WEST SUSSEX COUNTY COUNCIL CONSULTATION

TO:	Arun District Council FAO: Raymond Cole
FROM:	WSSC - Highways Authority
DATE:	24 March 2020
LOCATION:	283-285A Chichester Road Bognor Regis PO21 5AH
SUBJECT:	BR/327/19/DOC Approval of details reserved by condition imposed under ref BR/324/17/PL relating to Condition No 3 - surface water drainage, 4 - Pre-commencement site meeting with Tree Officer, 5 - Construction Management Plan, 6 - existing public sewer and 7 - foul sewerage disposal. CMP and supporting documents and drawings received.
DATE OF SITE VISIT:	n/a
RECOMMENDATION:	No Objection
S106 CONTRIBUTION TOTAL:	n/a / £ See below for breakdown.

WSSC has been asked to discharge condition 5 which relates to a construction management plan., WSSC raise no objection.

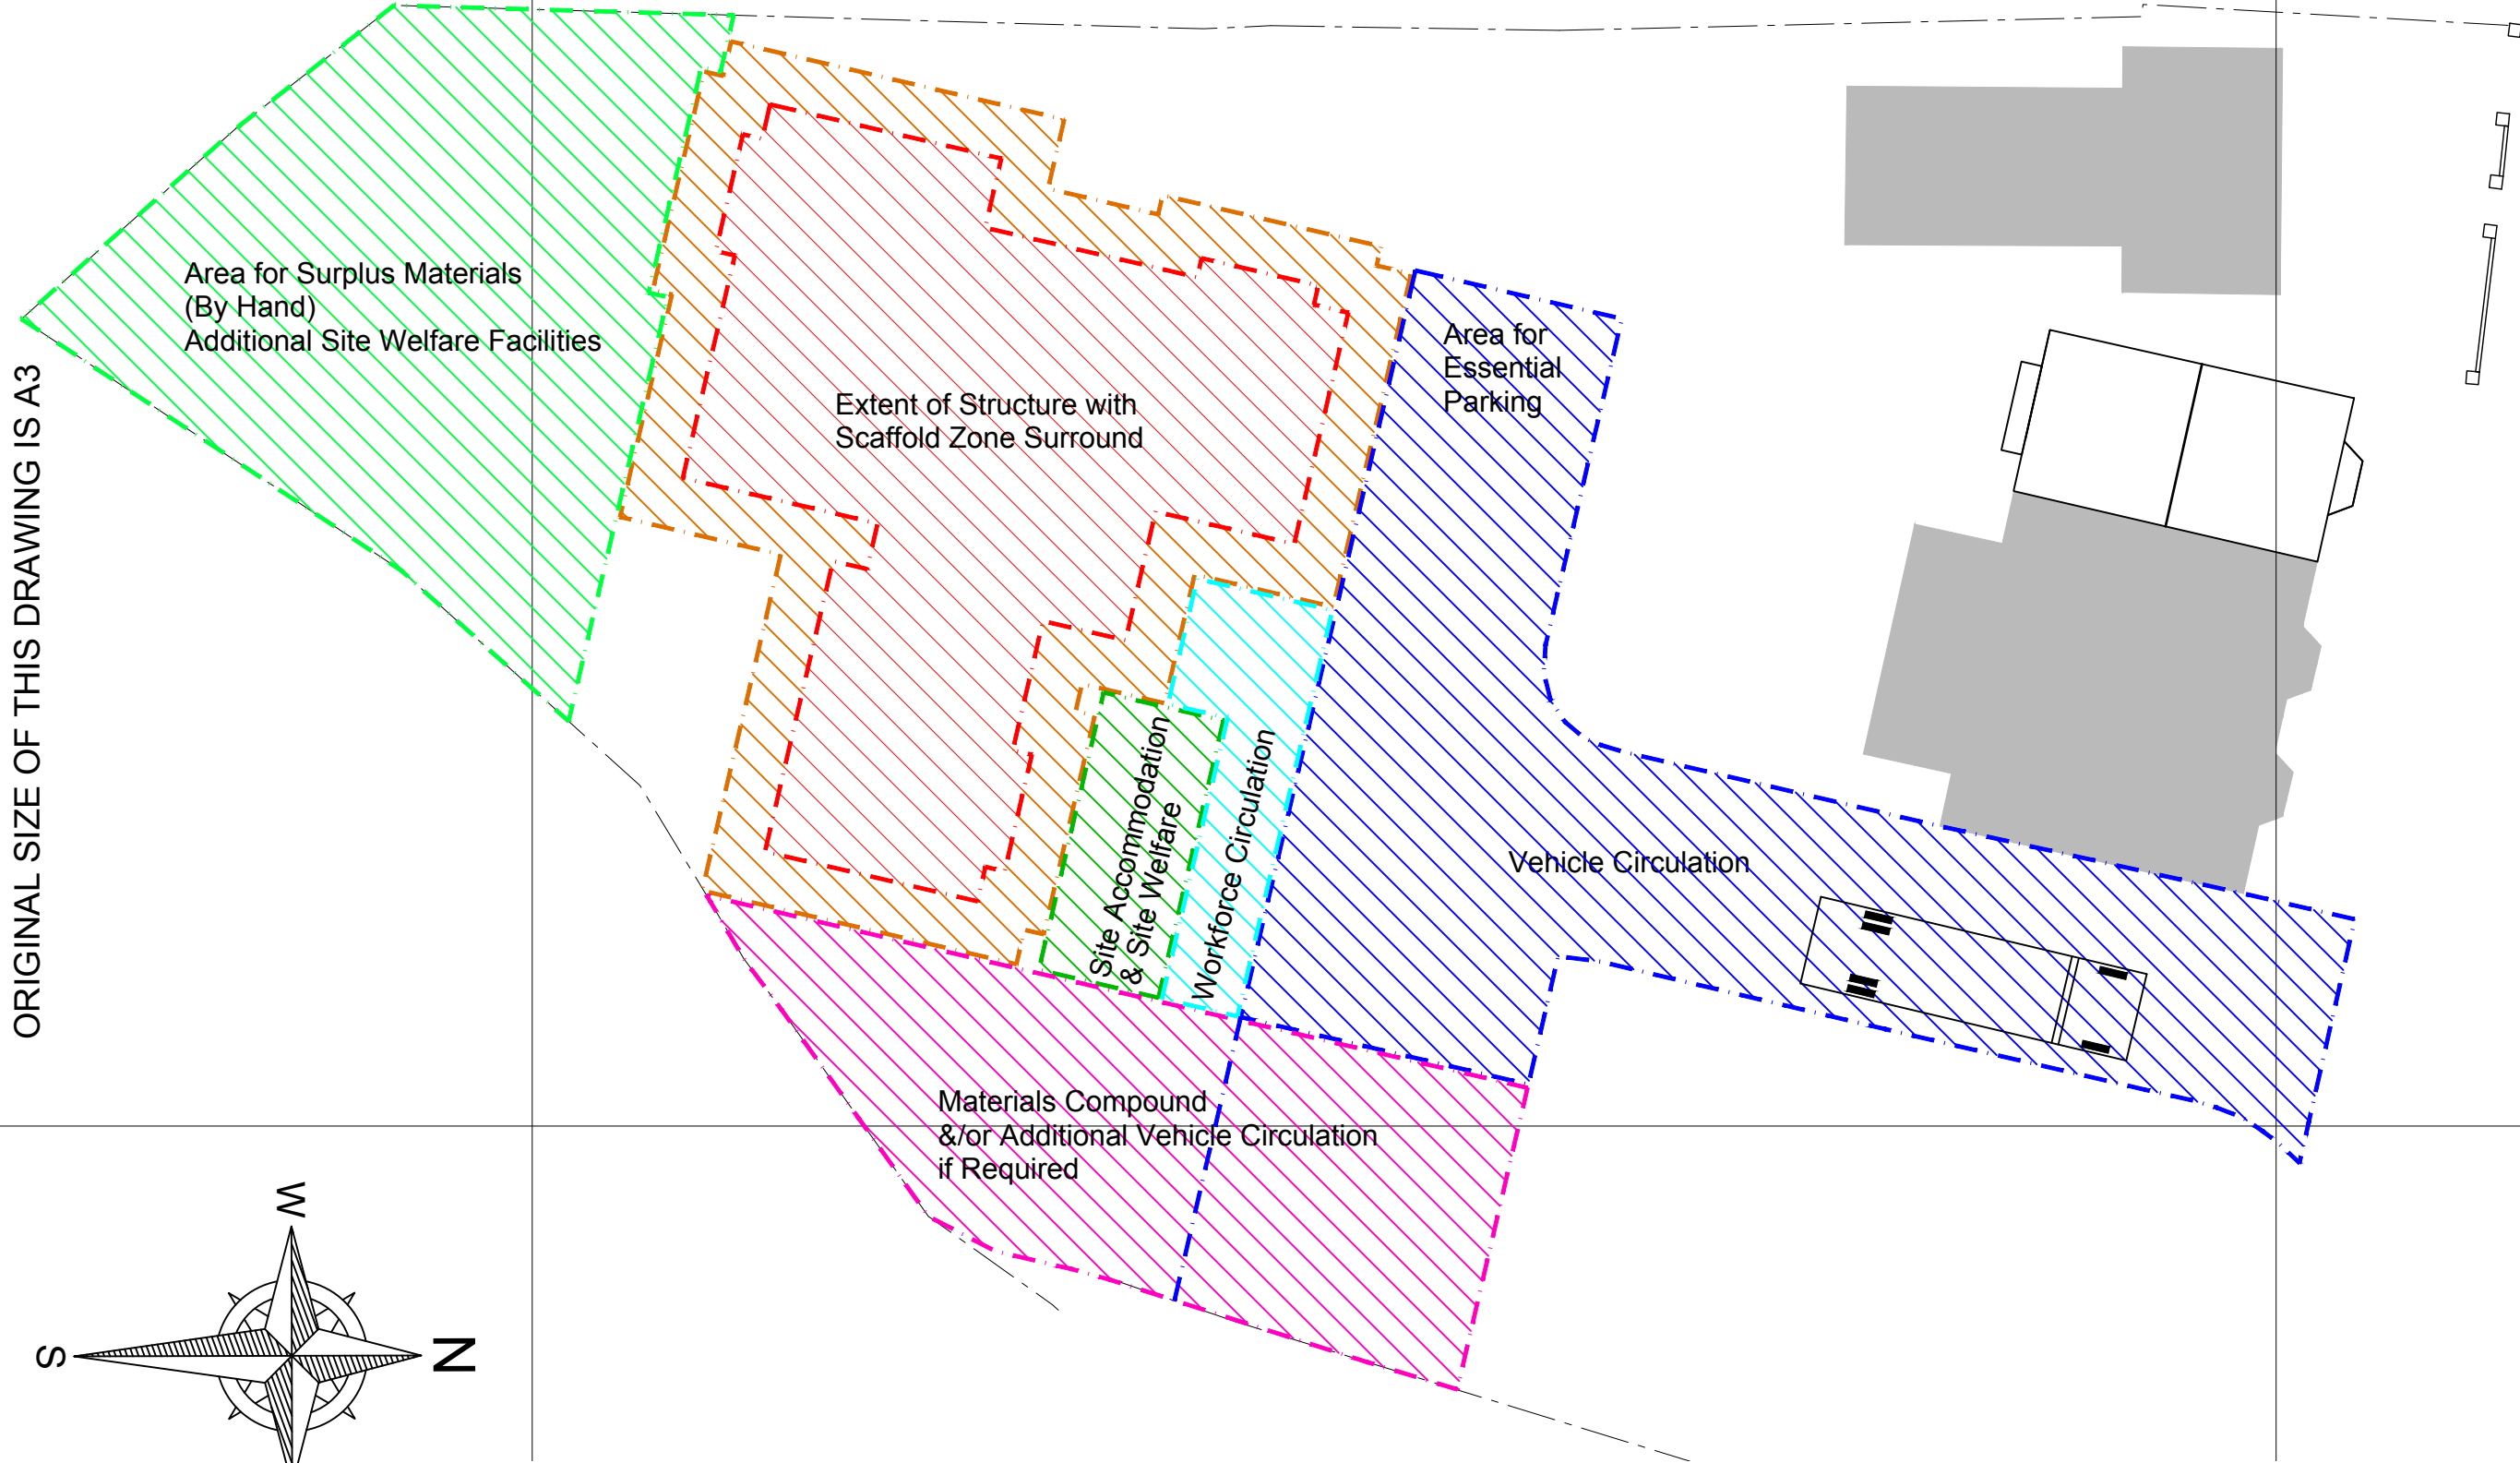
- Architects design and management condition 5
- Site compound areas as proposed drg site plan
- Transport planning technical note

- Swept path diagrams show the access will be wide enough to accommodate a large vehicle, such as a refuse vehicle, and whilst most contractor vehicles will be kept to smaller loads the site can accommodate 1 large vehicle at a time, with space to enter, turn and exit in forward gear if necessary.
